End 2 Elevation Grid Line 6

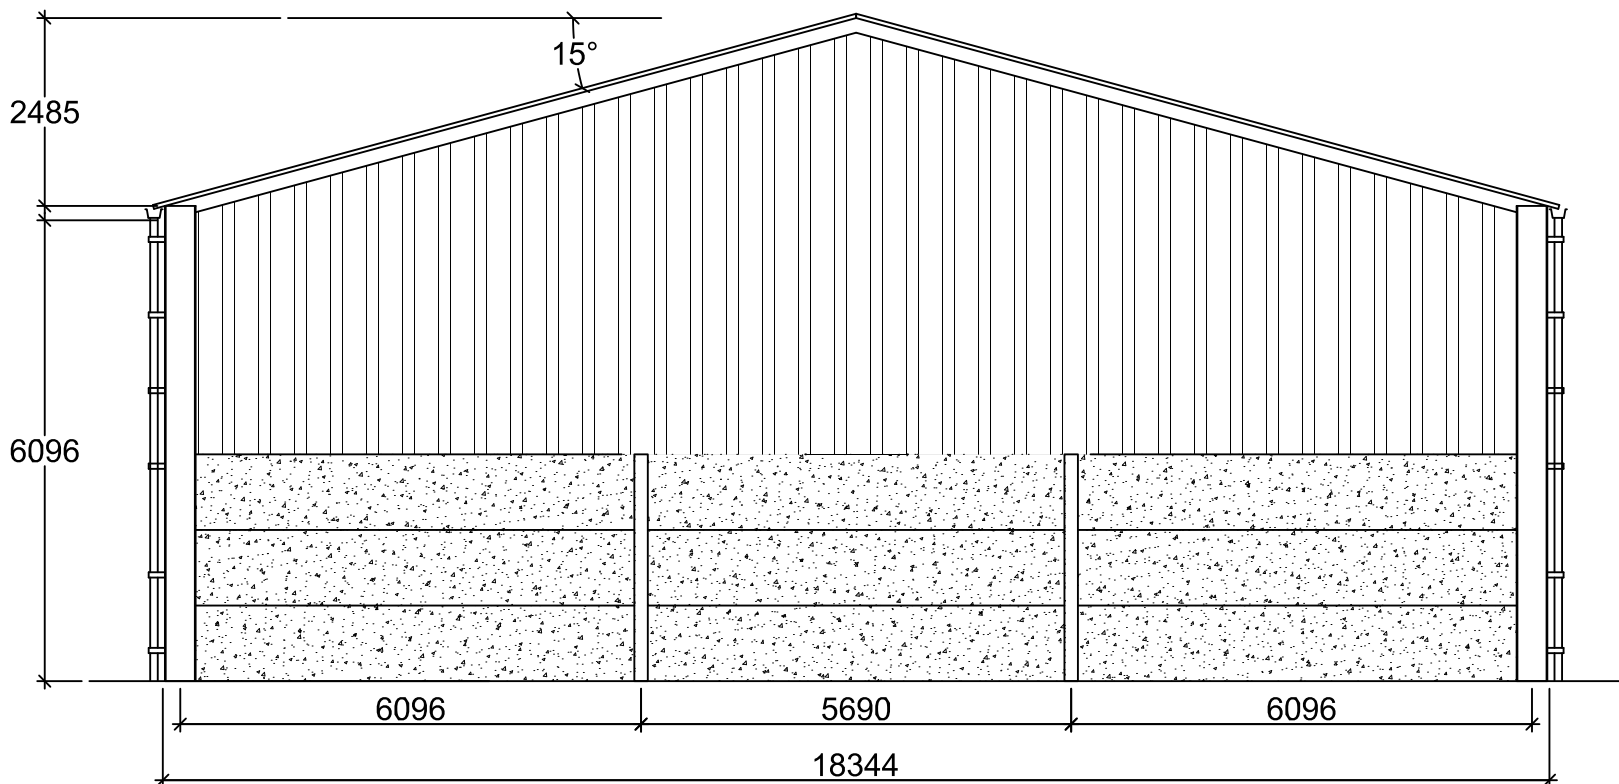
Please can you let me have a revised site plan and elevation plan indicating native tree planting along the southern boundary as discussed, by Wednesday next week?

Is there no option to reduce the width/length of the building slightly so that tree planting can be included within the red edge? Or to move the building forward or sideways within the red edge? A reduction in size would help to address our concerns and those of the Parish.

I have reconsulted the Ecologist based on the details submitted and await her response. In the meantime I would appreciate receipt of a revised site plan indicating the provision of native planting along the south elevation of the barn.

DRAWING TITLE
**Existing Location and Block Plan
PLANNING ISSUE**

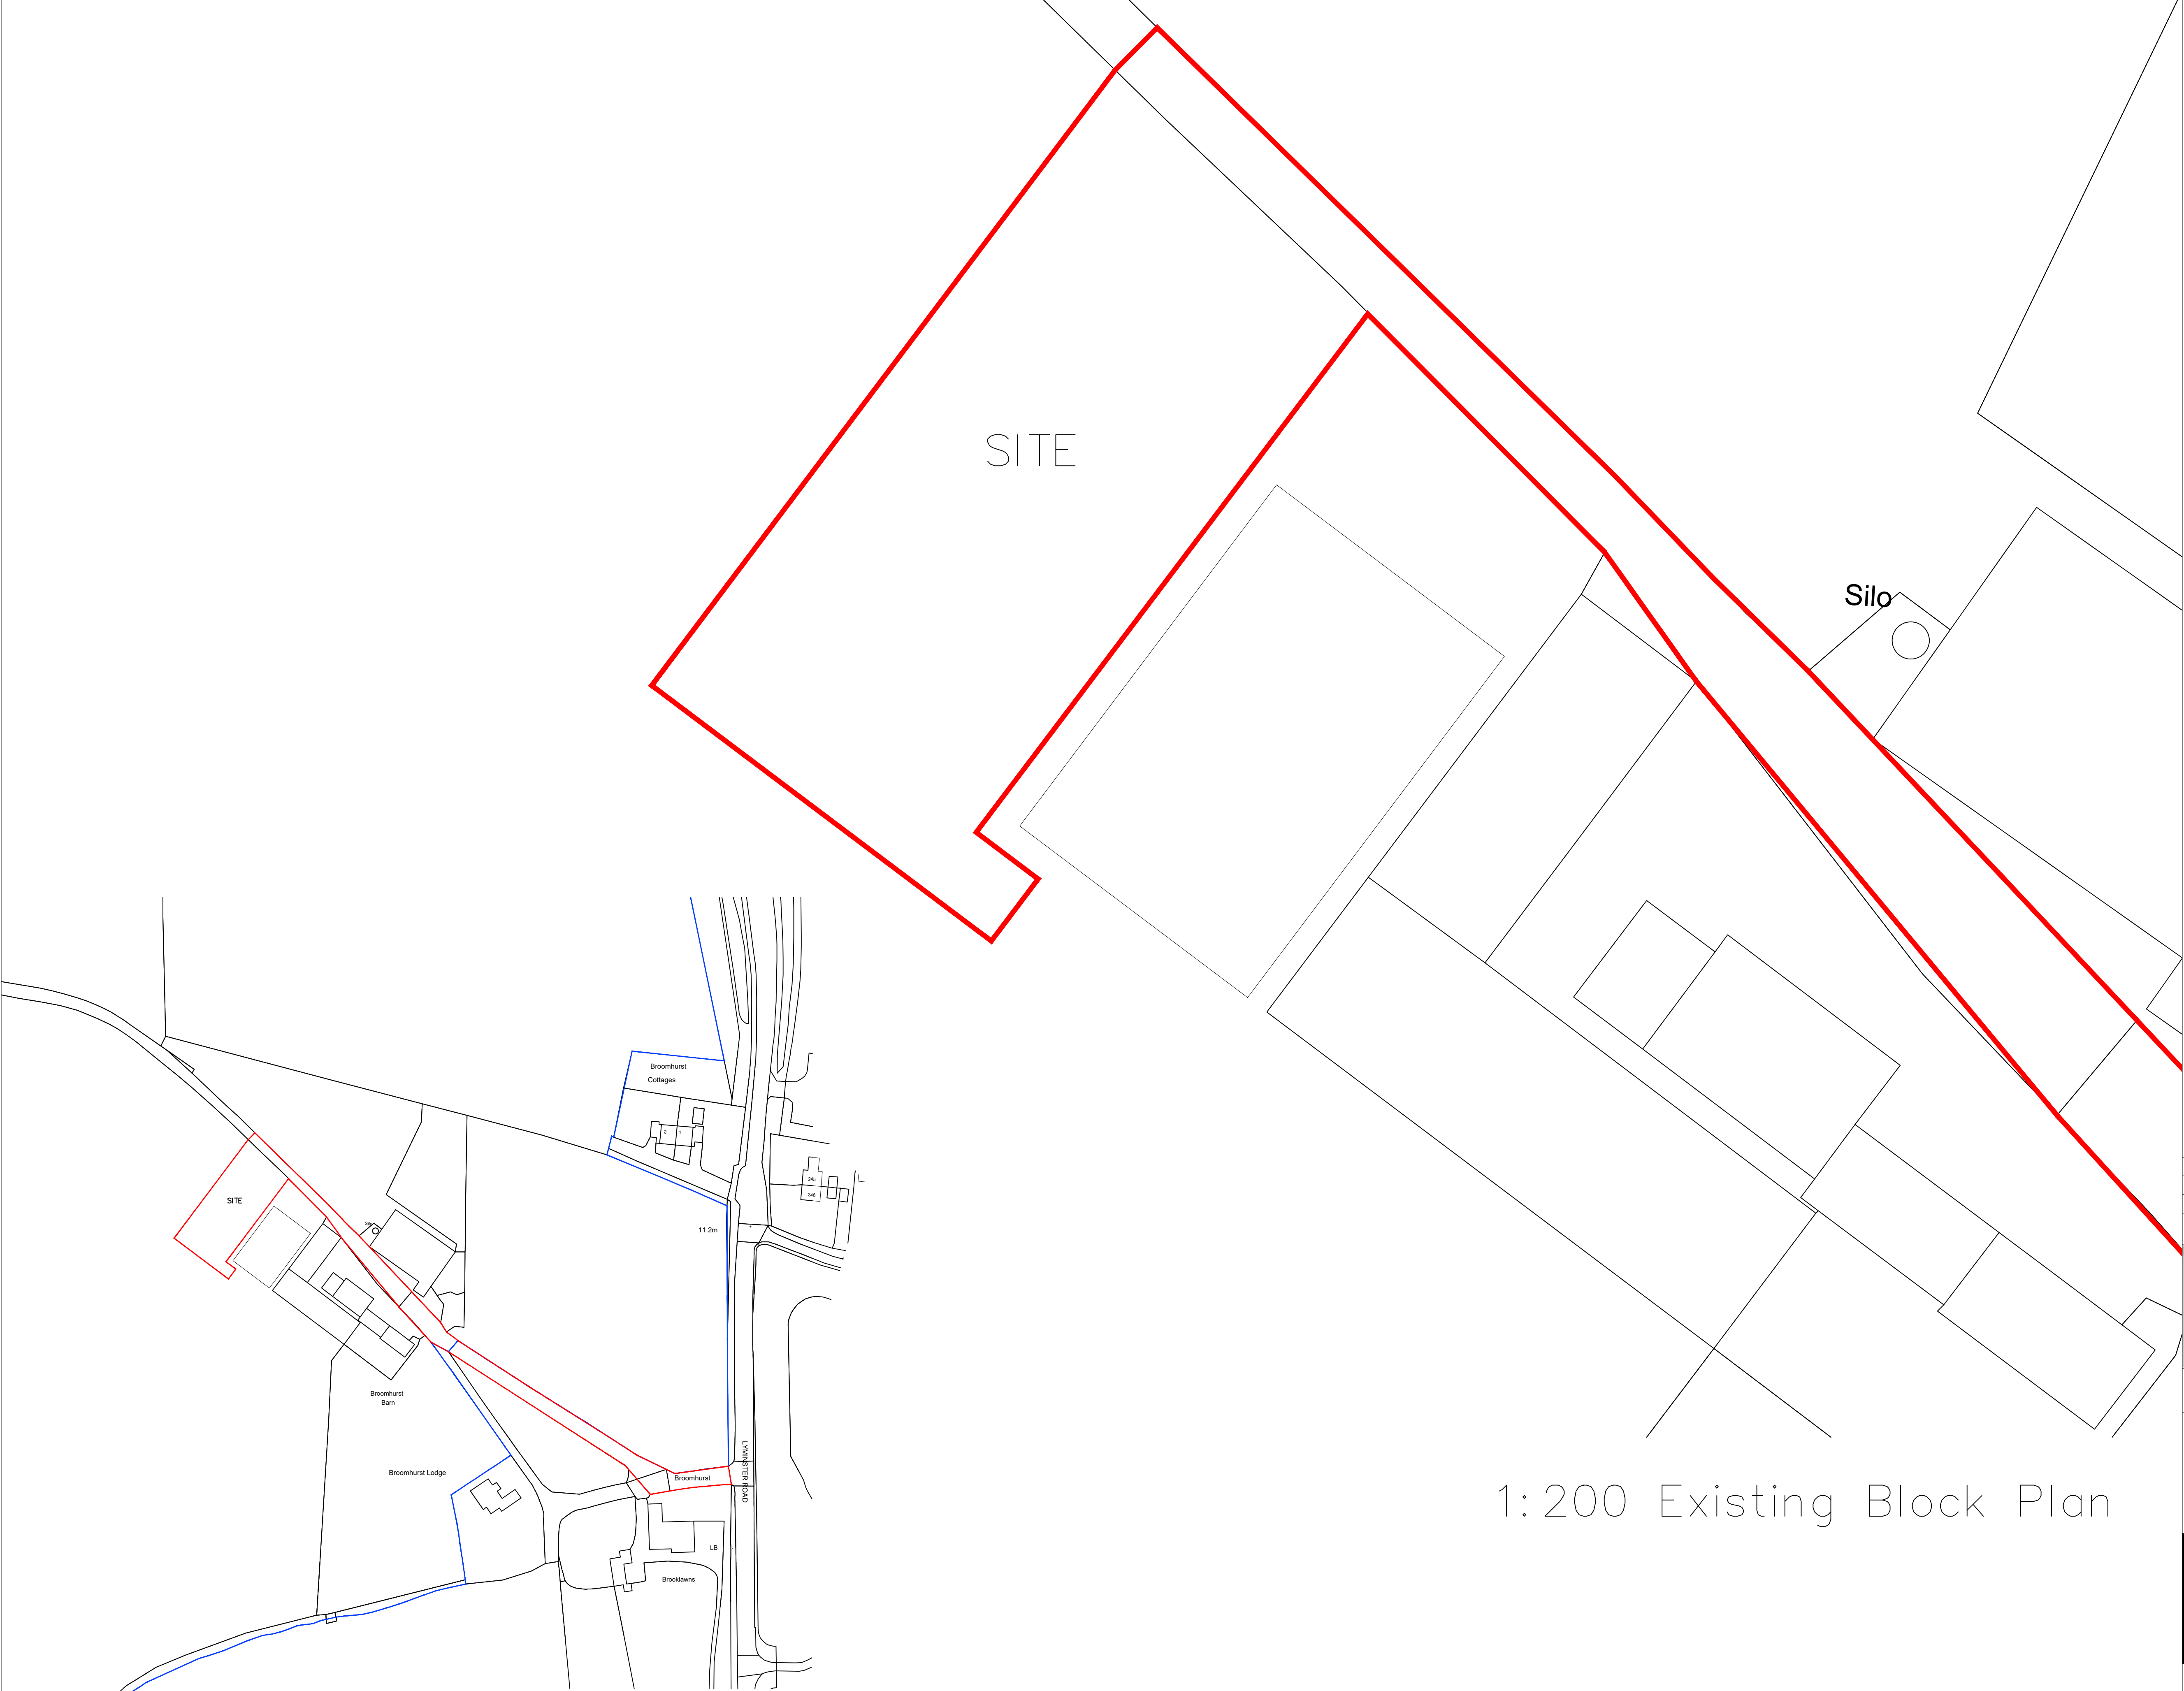
Thank you for your agreement which I have recorded. I have forwarded the elevation plan for substitution, but I haven't processed the site plan yet because the red edge hasn't altered to include the area of tree planting. Can you let me have a plan incorporating this change as soon as possible?

I have discussed the amended red edge to facilitate tree planting with my Team Leader and we can accept revised plans without the need for re-advertising.

Apologies for the misunderstanding, please find attached the revised Planning Issue drawings to reflect the revised red edge, to now include the area of trees immediately to the South West of the proposed building.
